Date: 23-Jun-2026
Our Ref: 2026/91192

**Application for a non-material amendment following a grant of planning permission,
Town and Country Planning Act 1990**

Non material amendment to previous permission 2024/91998 for erection of special educational needs and disabilities school (Use Class F1), comprising educational buildings, roof mounted photo-voltaic panels, sensory garden spaces, multi-use games areas, landscaping, hardstanding areas, carparking, access with secure fencing and associated ancillary development
Former, Almondbury High School, Fernside Avenue, Huddersfield, HD5 8PQ
Application Number: 2026/91192

TITLE
EXTERNAL LIGHTING SHEET 2 OF 2

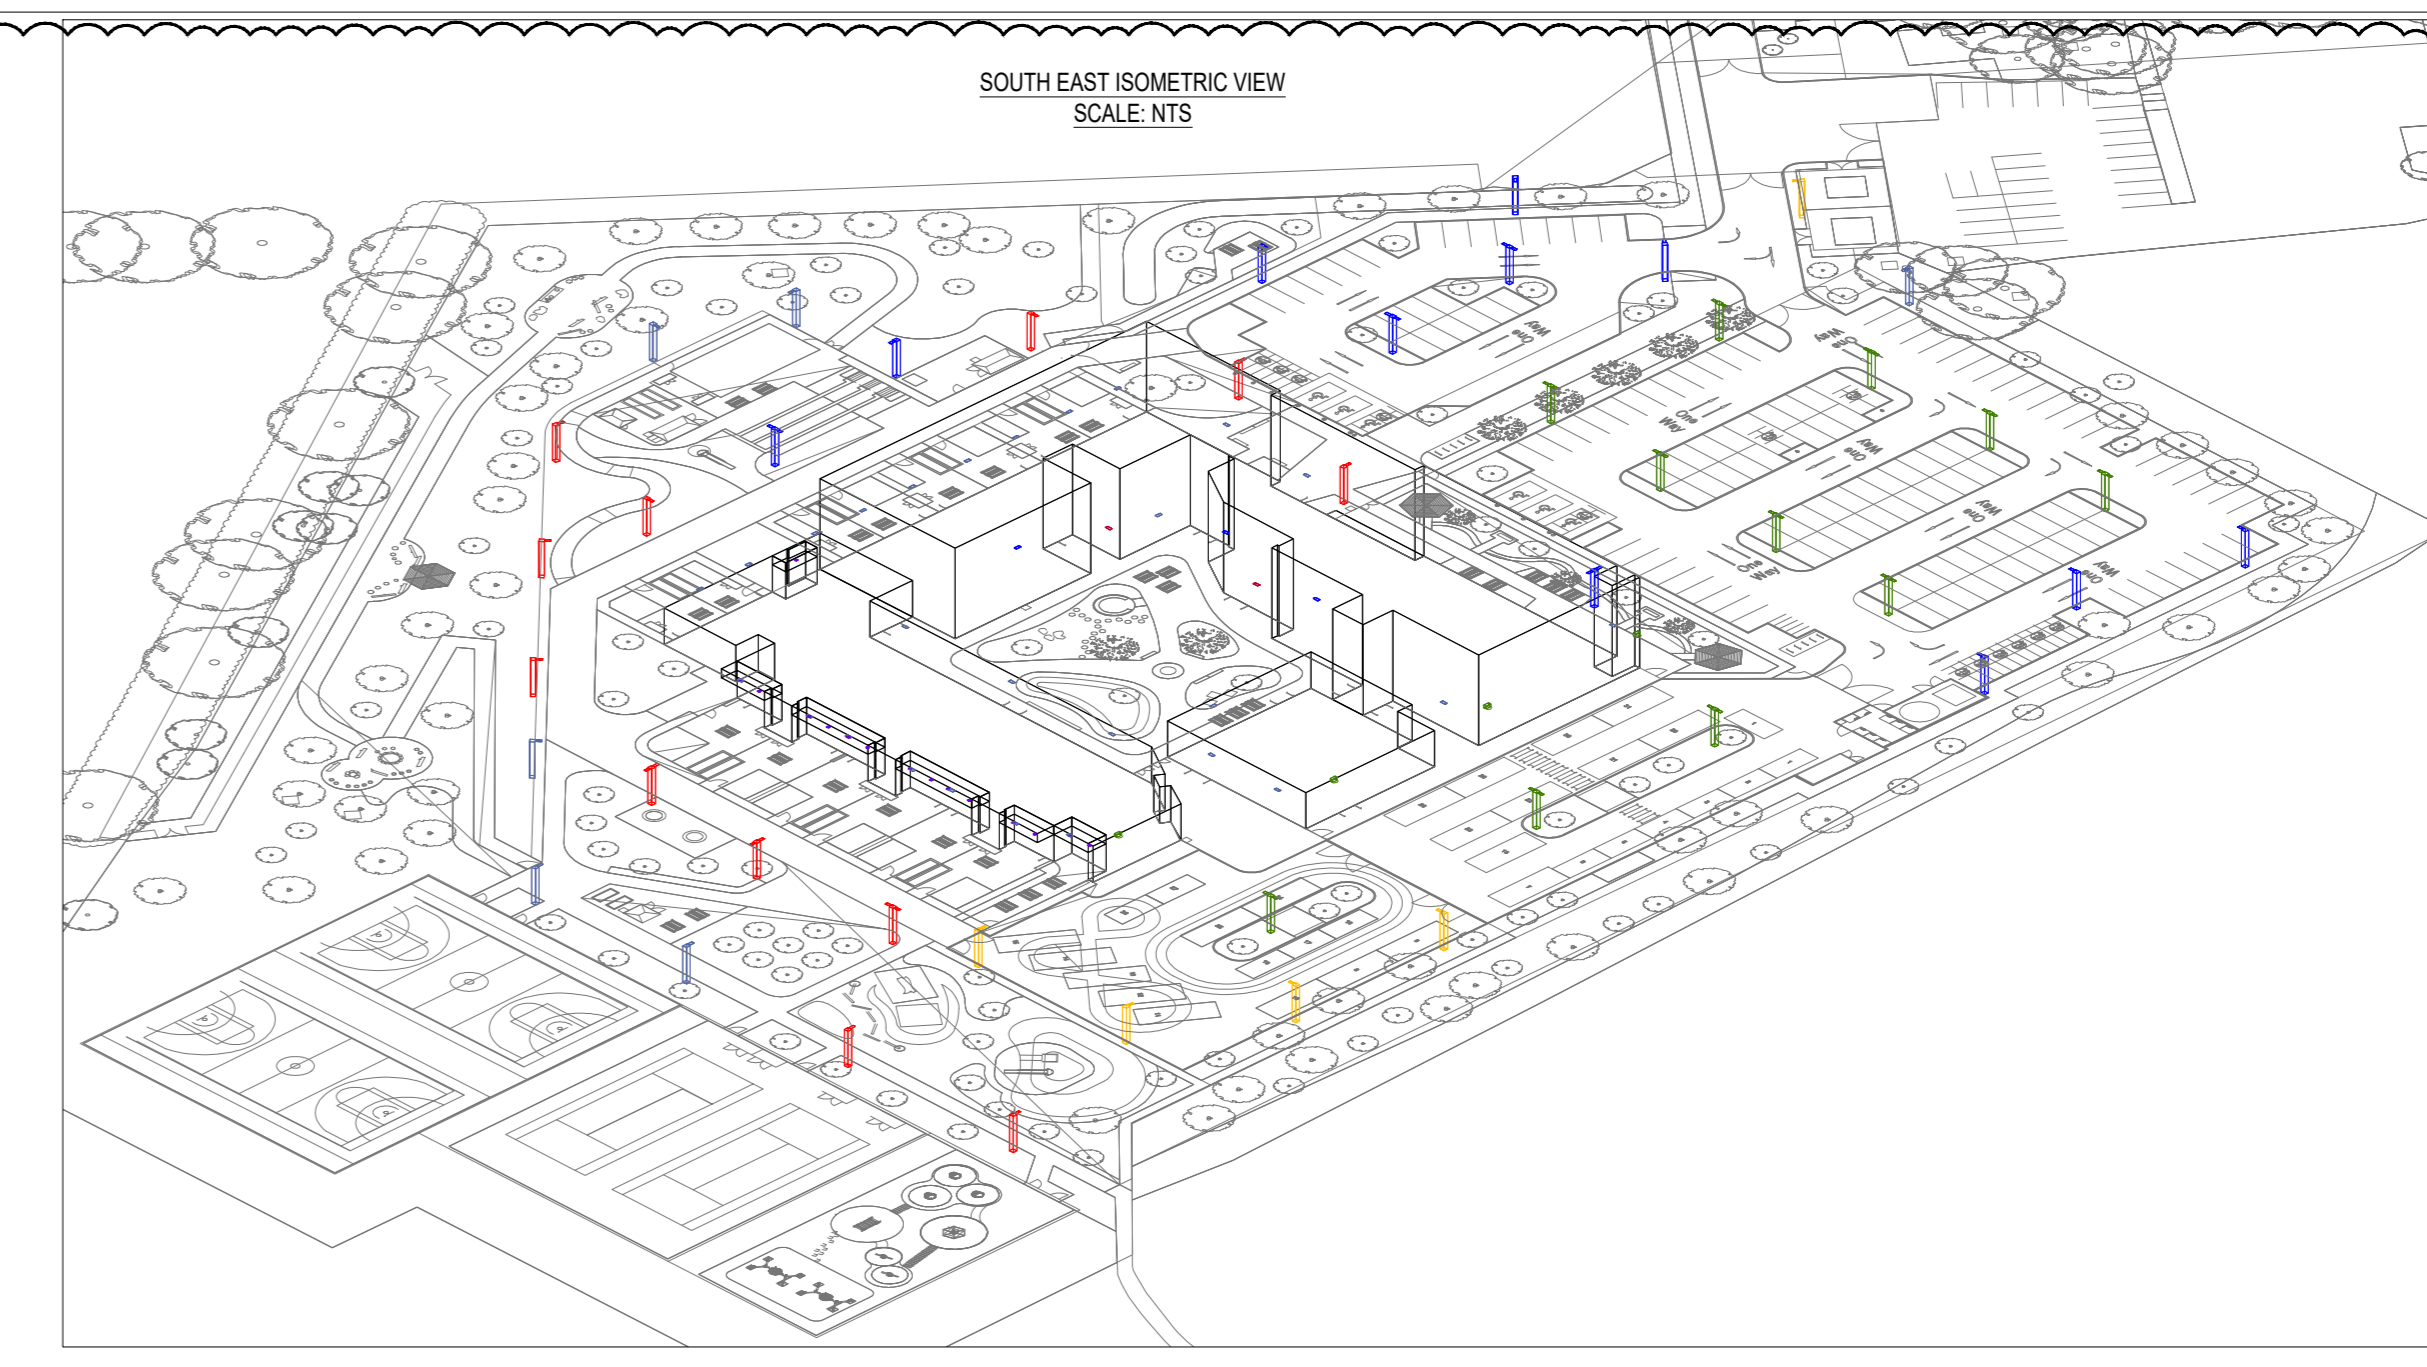
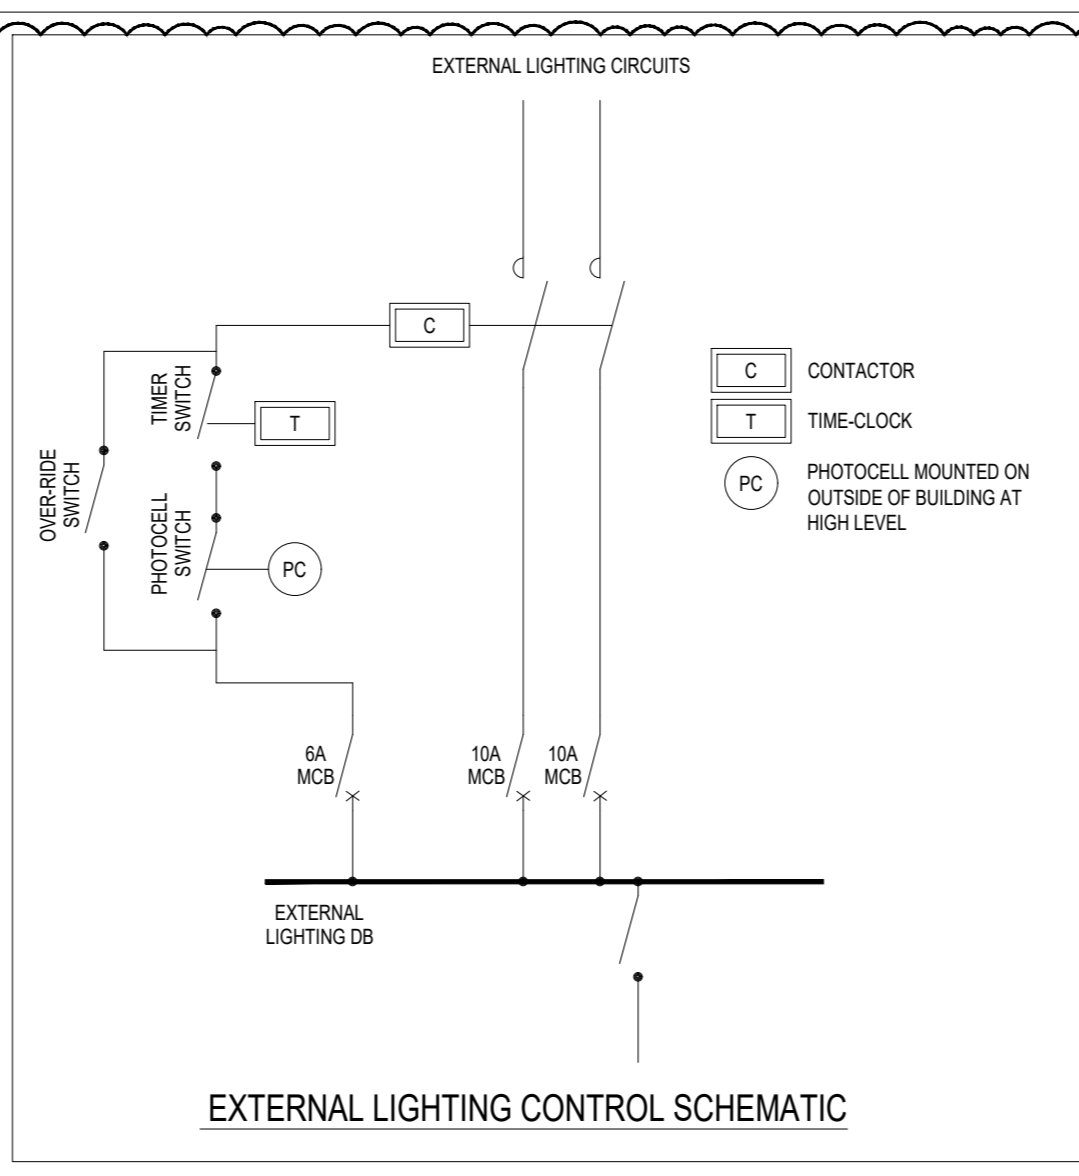
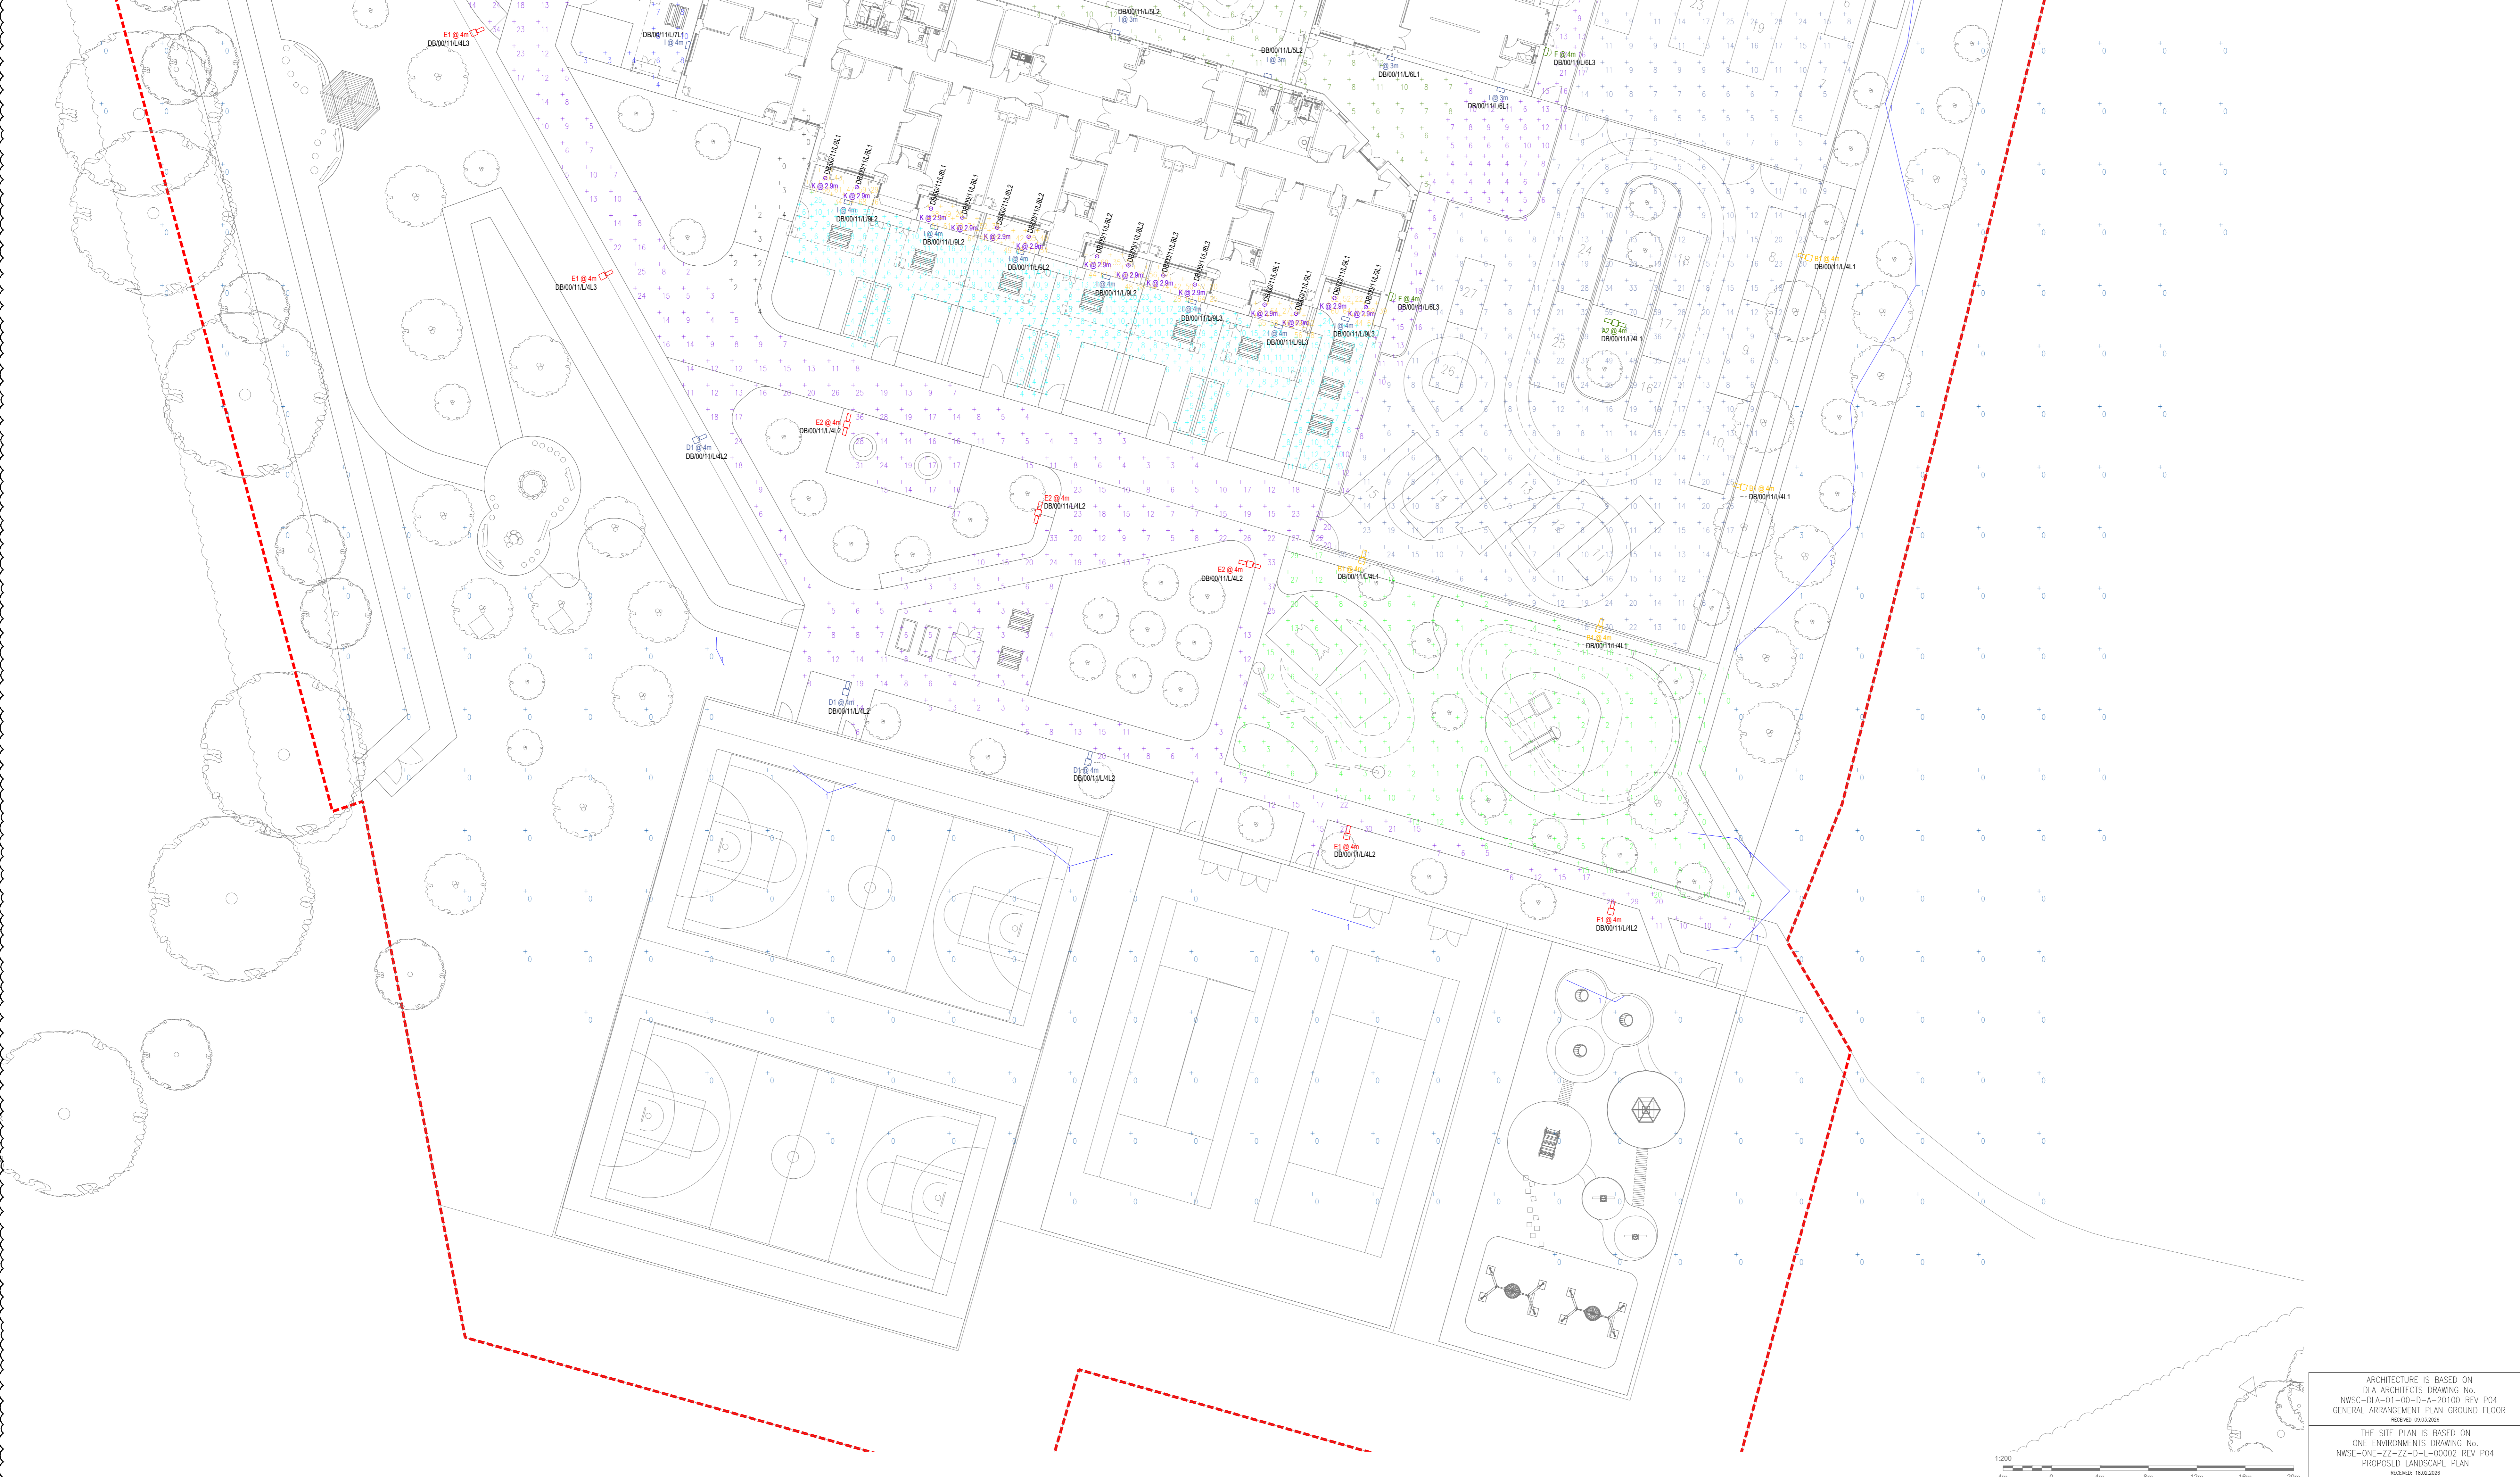
- Whilst the specification of the lighting remains unchanged, an updated lighting drawing has been prepared to reflect changes following Stage 4 Design.

20. The external lighting for the play area shown on hereby approved drawing no. NWSC-GAH-00-00-D-E-01101-External Lighting Sheet 1 of 2-S3-P03 & NWSC-GAH-00-00-D-E-01102-External Lighting Sheet 2 of 2-S3-P03, and any external lighting erected for the MUGA's, shall only be operated between –
